From: Claire Potts
Sent: 20 July 2016 12:33
To: Reimnitz-Wood, Jordan; Barber, Robert
Subject: FP/145/16/DOC - Comments

Please see my comments below on the above discharge of conditions application:

Condition 8: Landscaping requires both hard and soft landscaping plans to be submitted as well as a tree protection plan.

Scale
1 : 250@A0
Drawing No.
D1530.L.901

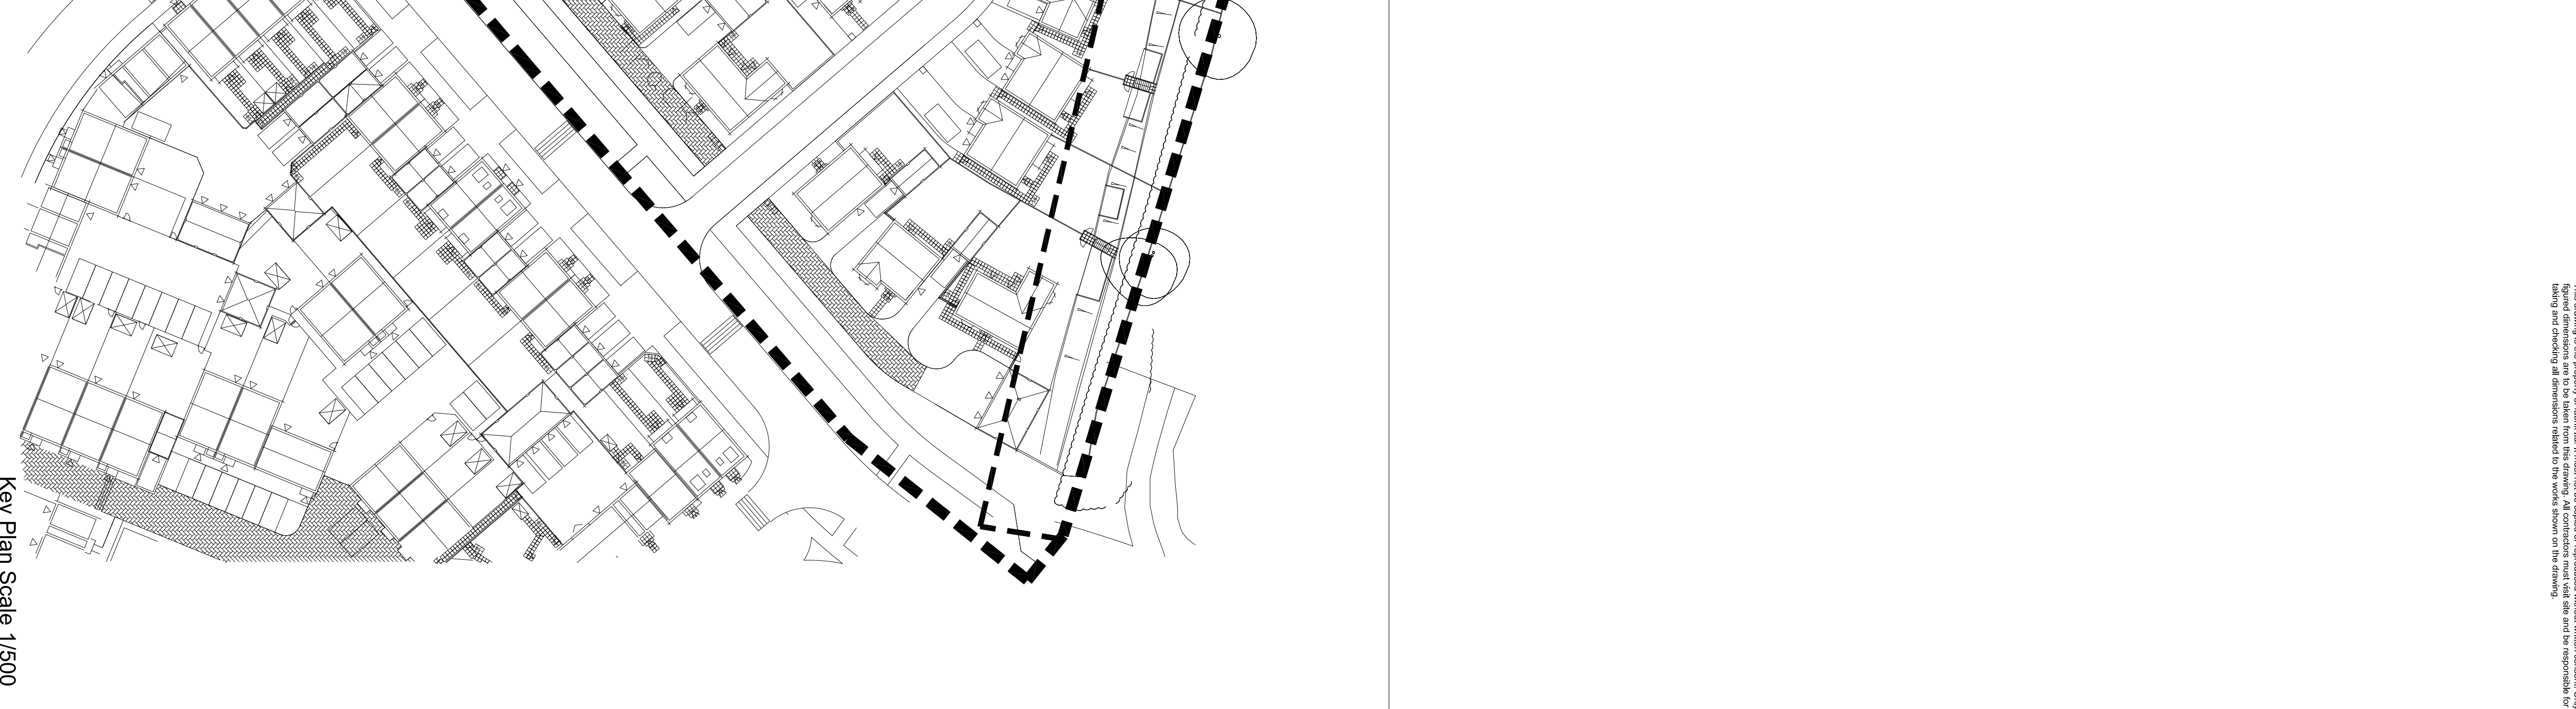
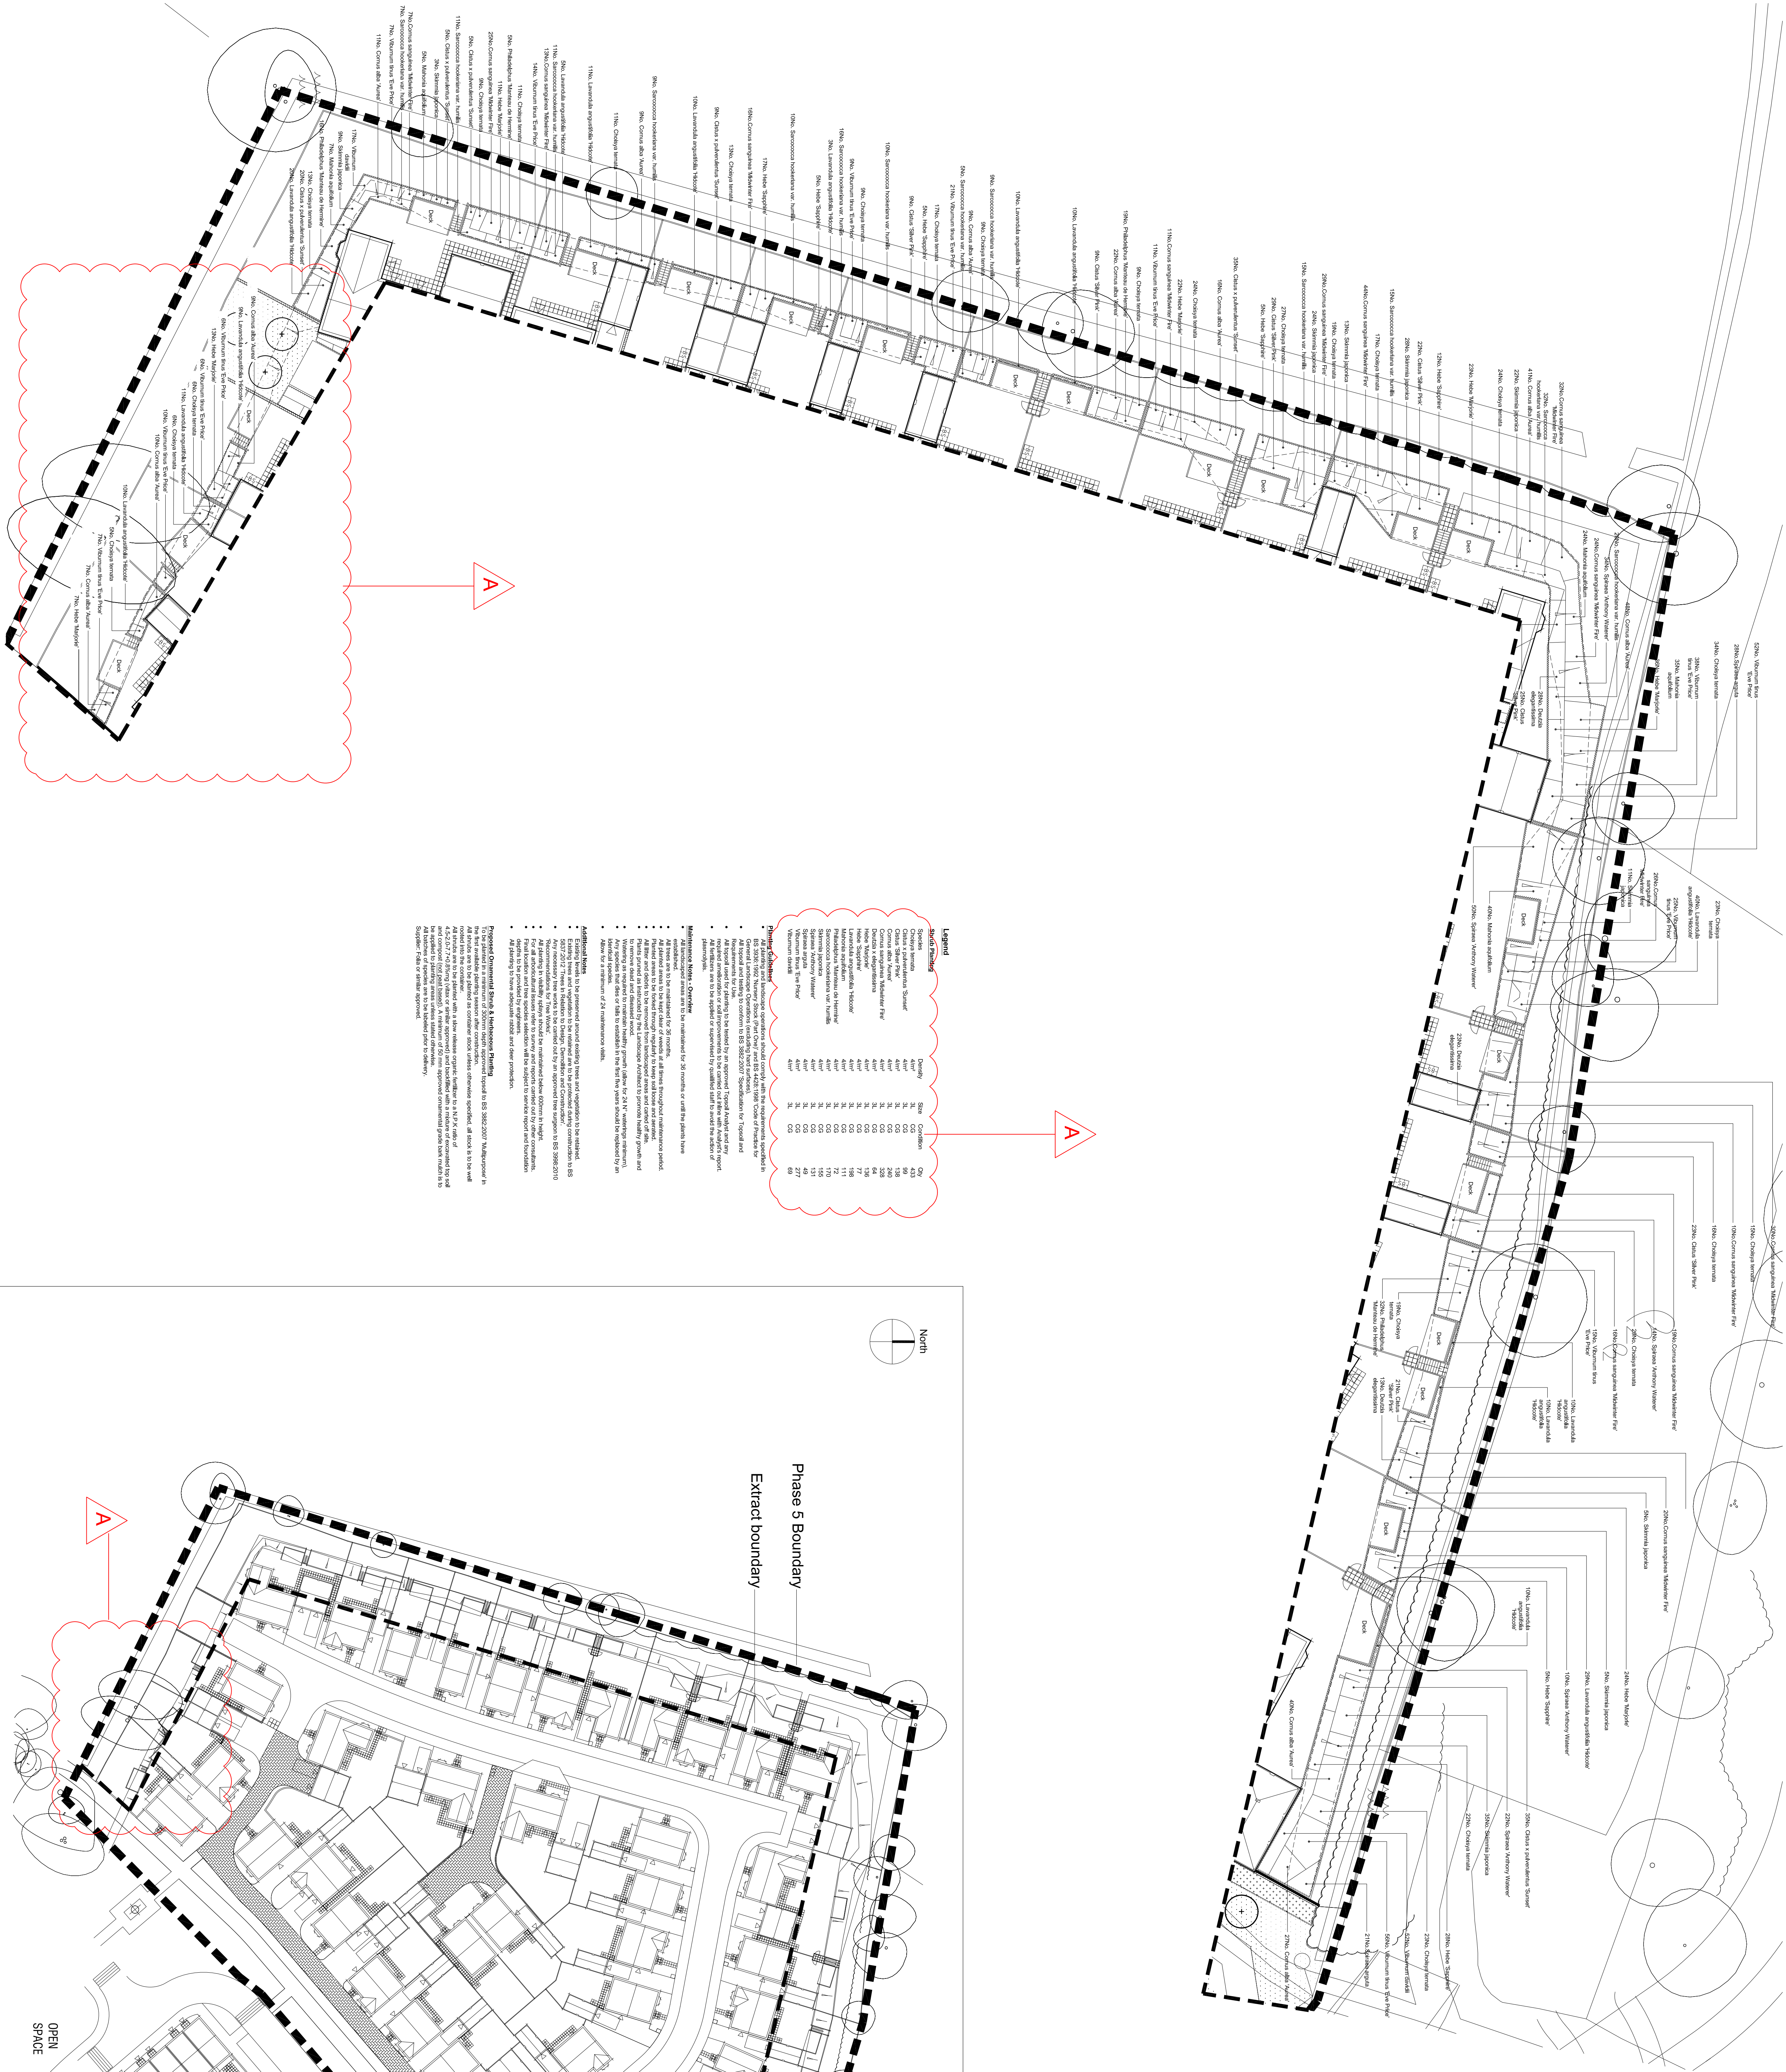
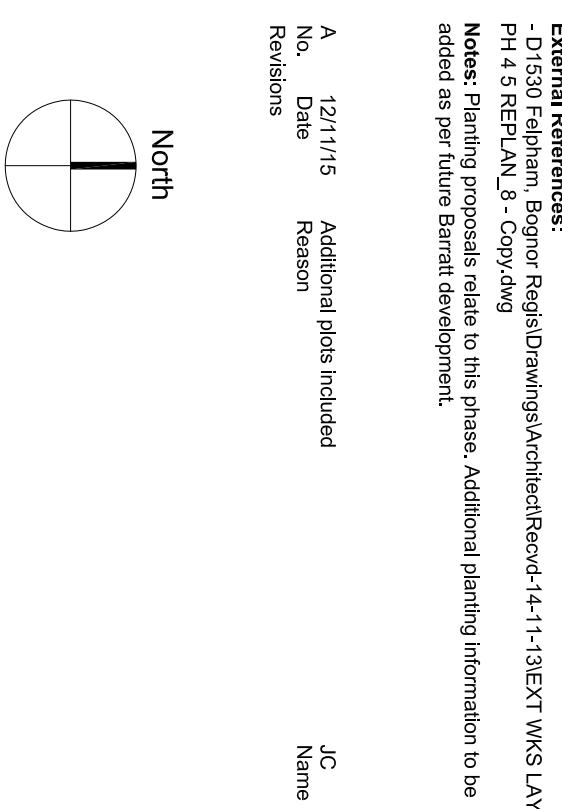
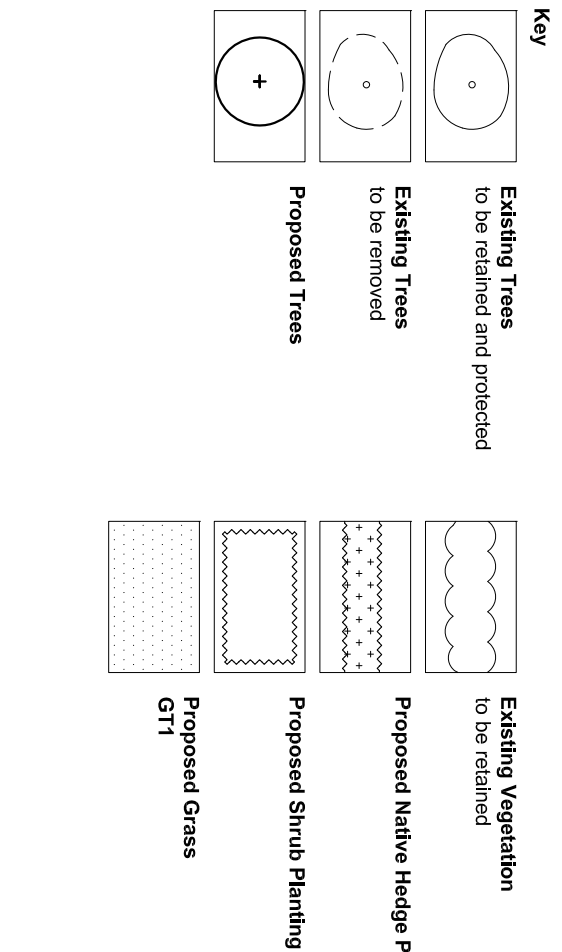
Needs to show appropriate porous surfacing for the cycle path – to be consistent with FP/55/15/PL. The two planting plans show Options (D1530.L.901 rev.A – showing shrub planting) and (D1530.L.902 – showing meadow grass) for the earth bank – either meadow grass or shrubs. From visiting the site it appears that the gardens have been completed – therefore the plans should only show the relevant option as implemented on the ground.

Drawing No.
D1530.L.700

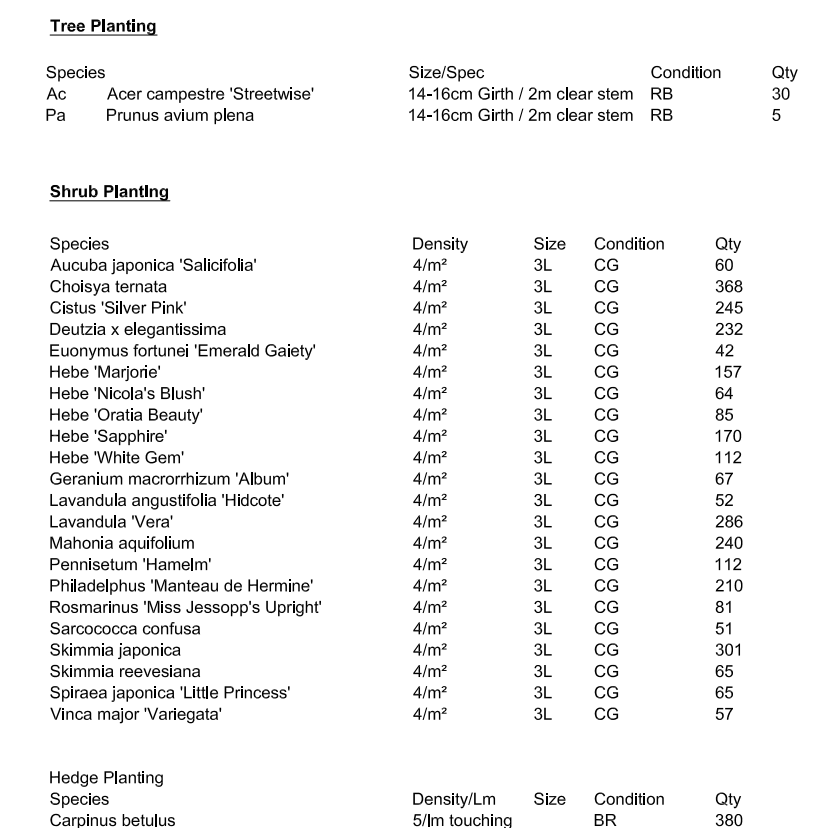
Detailed Planting Plan D1530.L.700 – doesn't clearly show existing trees to be retained and how they relate to the proposed landscaping.
